Plan Review, Inspection, and Permit Fees

Application Number : **FMFW1808-0002**

Fire Marshal Division

Re: Campbell University Street Fair
Application Number: FMFW1808-0002

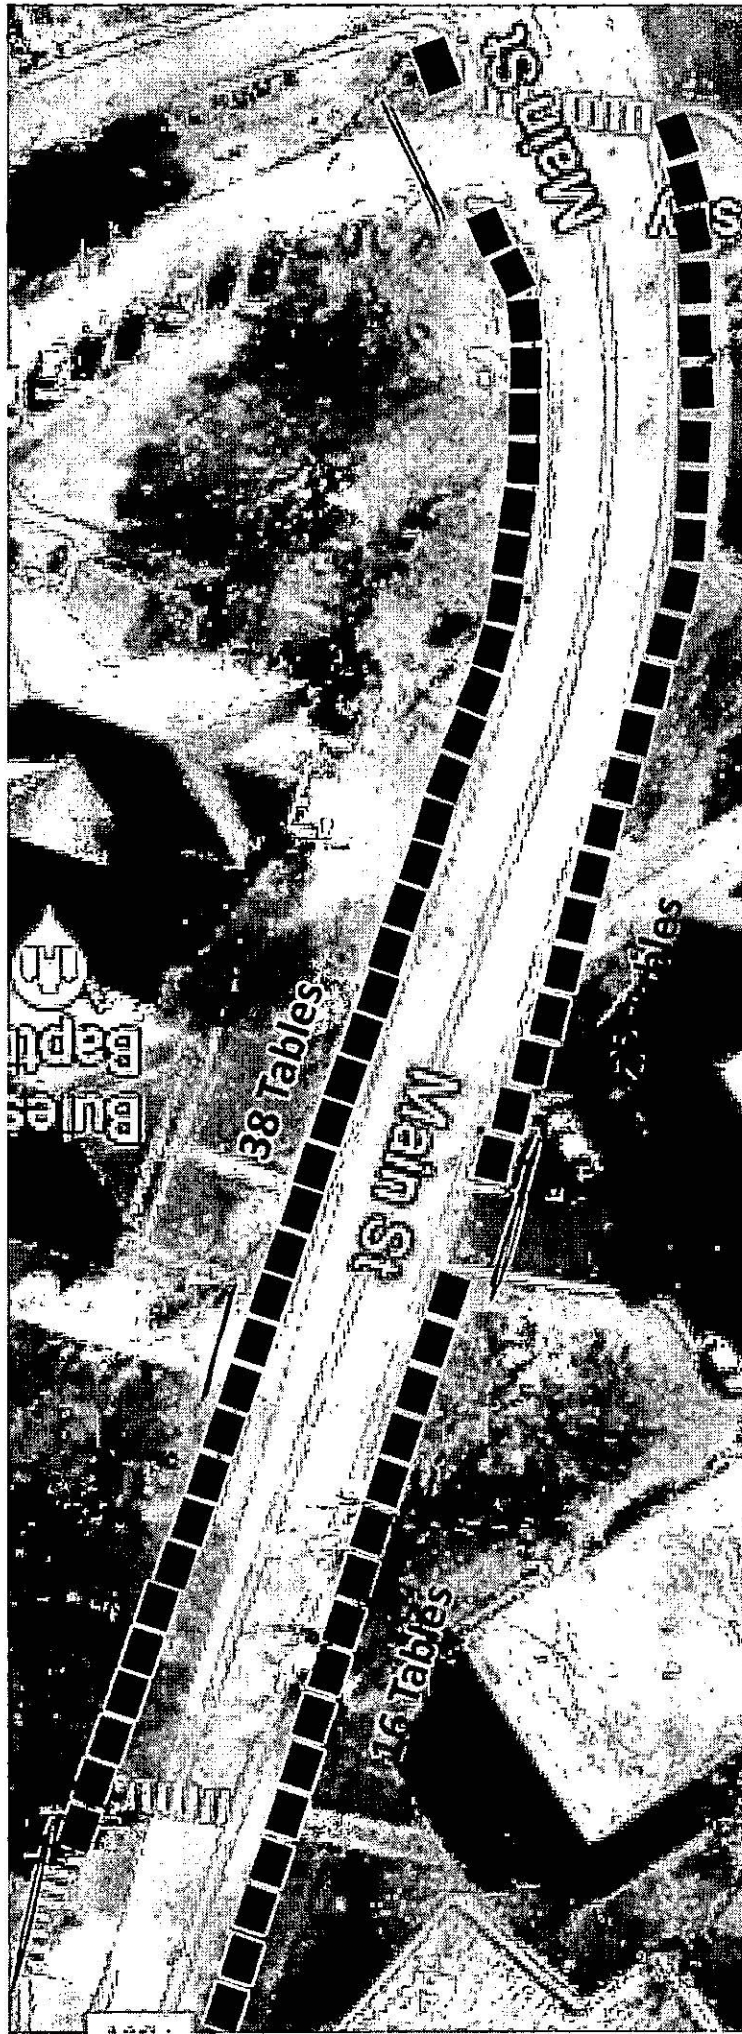
- **Permits**
 - A permit will be issued for the special assembly that will include the event as a whole.
 - A permit may be issued for other tent areas if the individual tent exceeds 700 ft² or the aggregate area of multiple canopies placed side by side without a fire break clearance of 12'
- **Fire Extinguishers**
 - Portable fire extinguishers shall be provided within a 30-foot (9144 mm) travel distance of commercial-type cooking equipment. Cooking equipment involving vegetable or animal oils and fats shall be protected by a Class K rated portable extinguisher.
 - 2A-10B:C fire extinguisher shall be placed at tents/canopies with a travel distance not to exceed 100' from any fire extinguisher
- **2411.6 Outdoor cooking.**
 - Outdoor cooking that produces sparks or grease-laden vapors shall not be performed within 20 feet (6096 mm) from a tent, air-supported, air-

inflated or tensioned membrane structure, temporary membrane structure or canopy.

- **2415 Generators**
 - Generators and other internal combustion power sources shall be separated from tents, air-supported, air-inflated or tensioned membrane structures, temporary membrane structures or canopies by a minimum of 20 feet (6096 mm) and shall be isolated from contact with the public by fencing, enclosure or other approved means.

- **2413.3 Refueling.**
 - Refueling shall be performed in an approved location not less than 20 feet (6096 mm) from tents, air-supported, air-inflated or tensioned membrane structures, temporary membrane structures or canopies.
